Our Case Number: ABP-318446-23

Re: Proposed construction of Coumnagappul Wind Farm consisting of 10 no. turbines and associated infrastructure.

Observation on a Strategic Infrastructure Development Application

**SERVICE UNDERCROSSING**

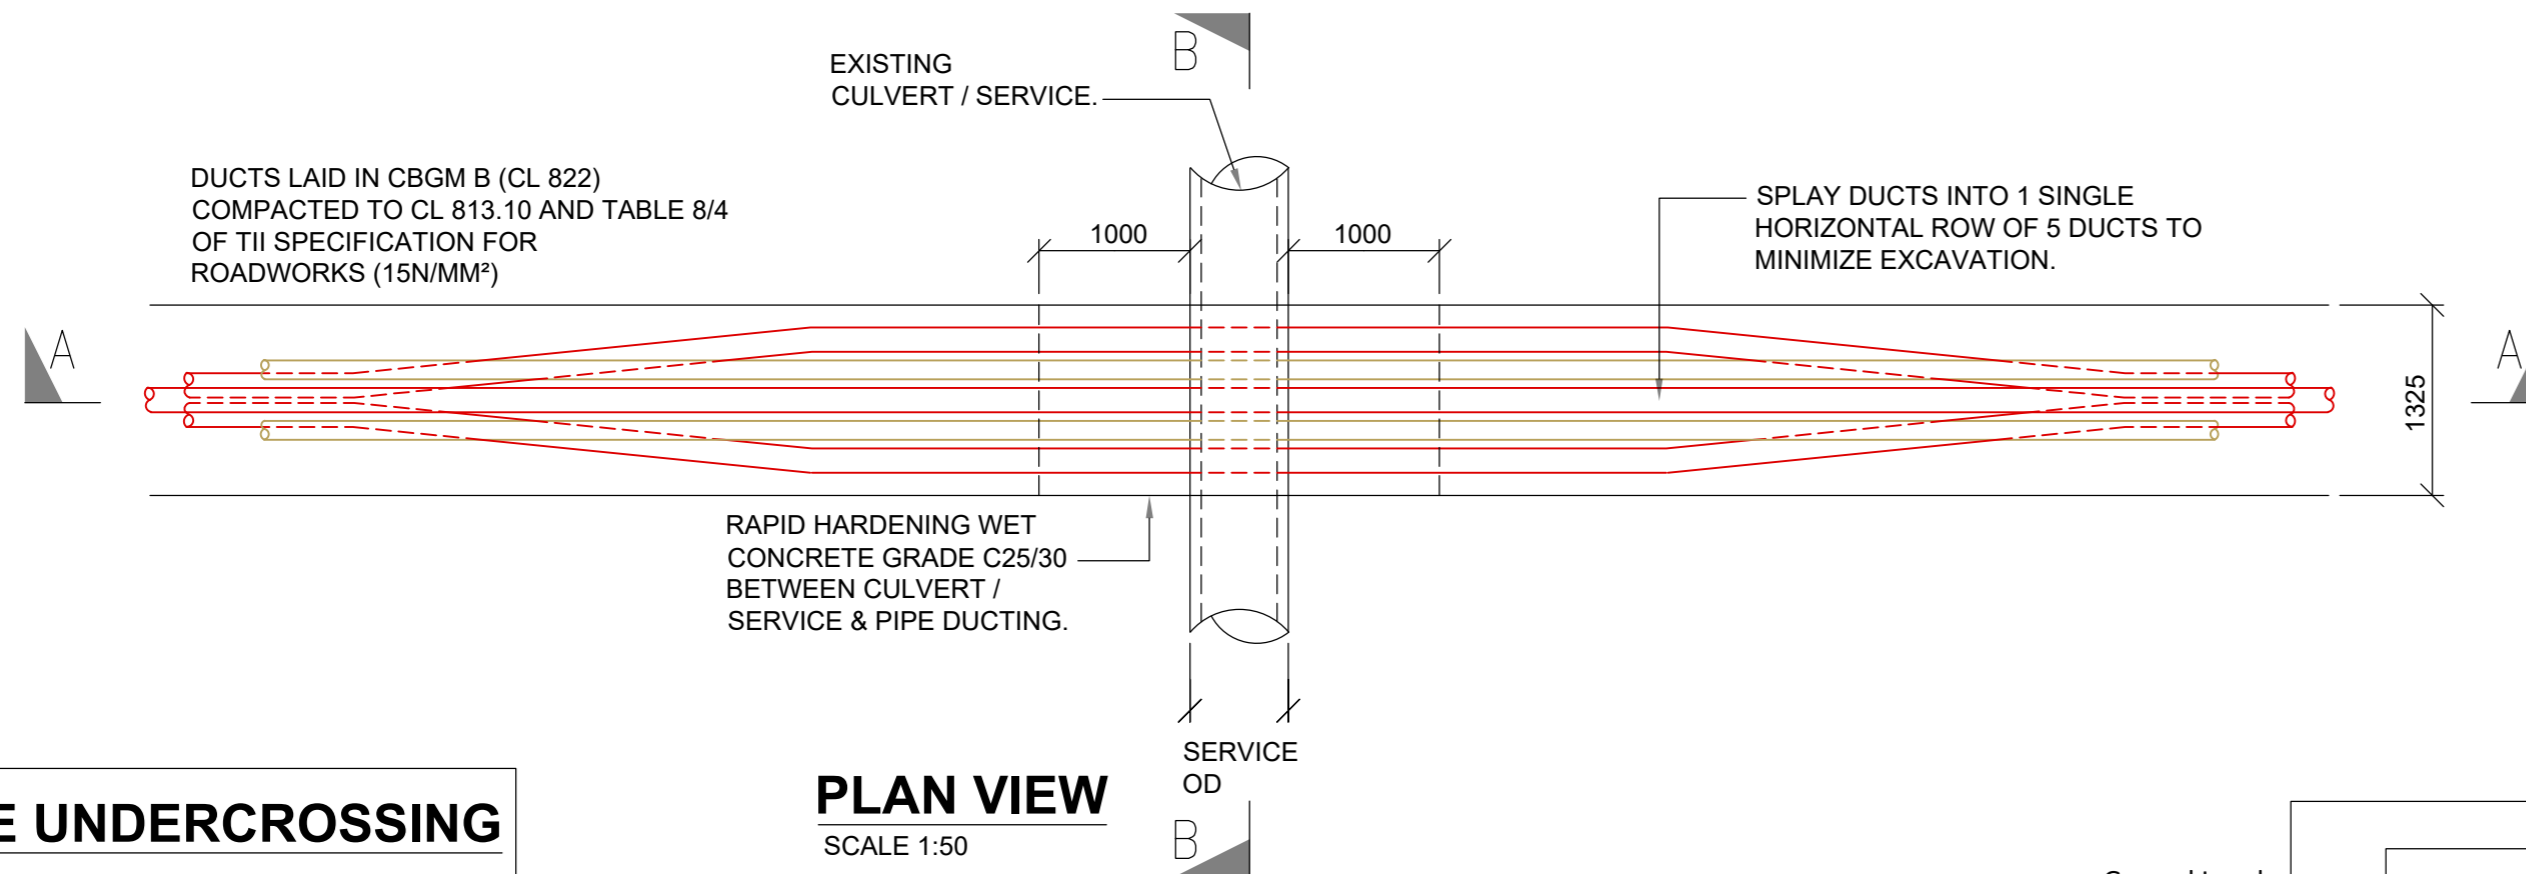
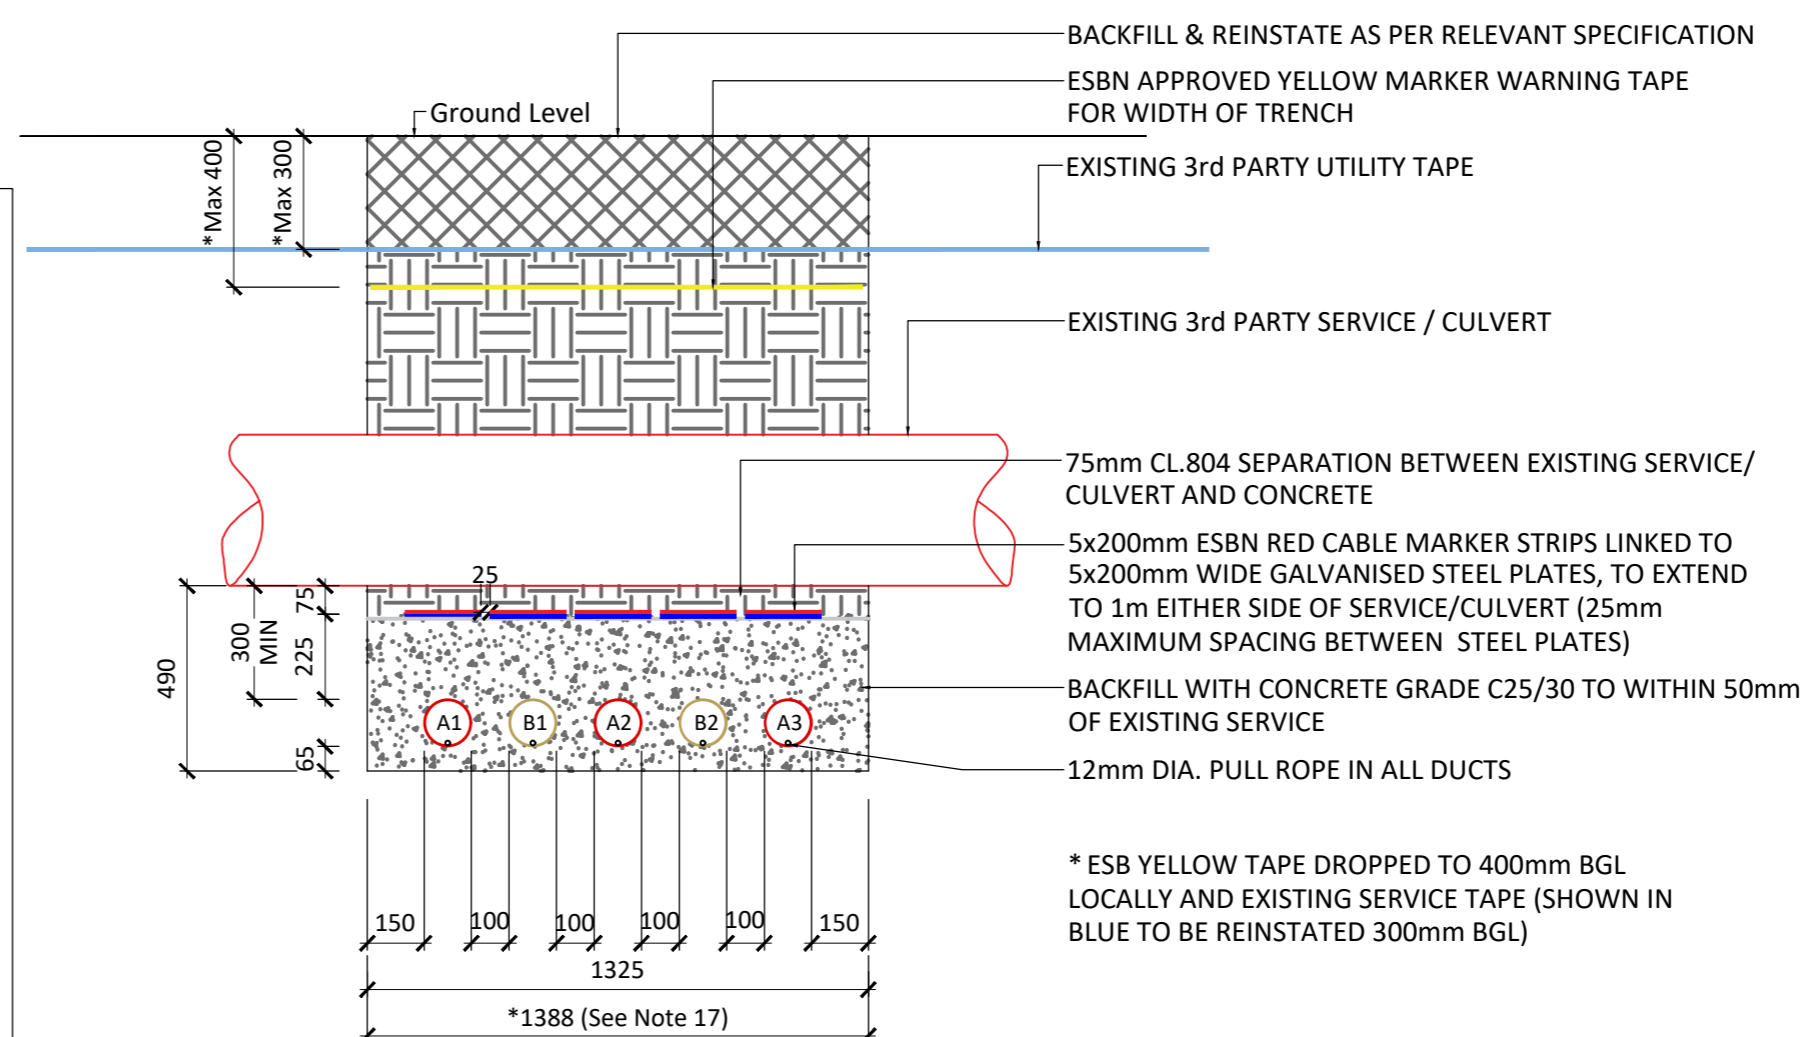
According to the applicant there already exists a culvert crossing of the Ballynaguilkee lower stream and they further state: on page 16. Eiar/vol ii ch 12.

'The crossing method will use a culvert undercrossing or over crossing method which will be selected based on the cover available above the culvert..'

They then go on to state:

'Where it is not possible to cross under the existing culvert in place, the culvert maybe replaced..'

Therefore I contend that the applicant has failed to show a definitive construction method in this regard, with their survey showing to be incomplete in relation to this grid connection water crossing and cannot be seen to represent a clear representation of their intent and as such planning should be refused on said grounds.
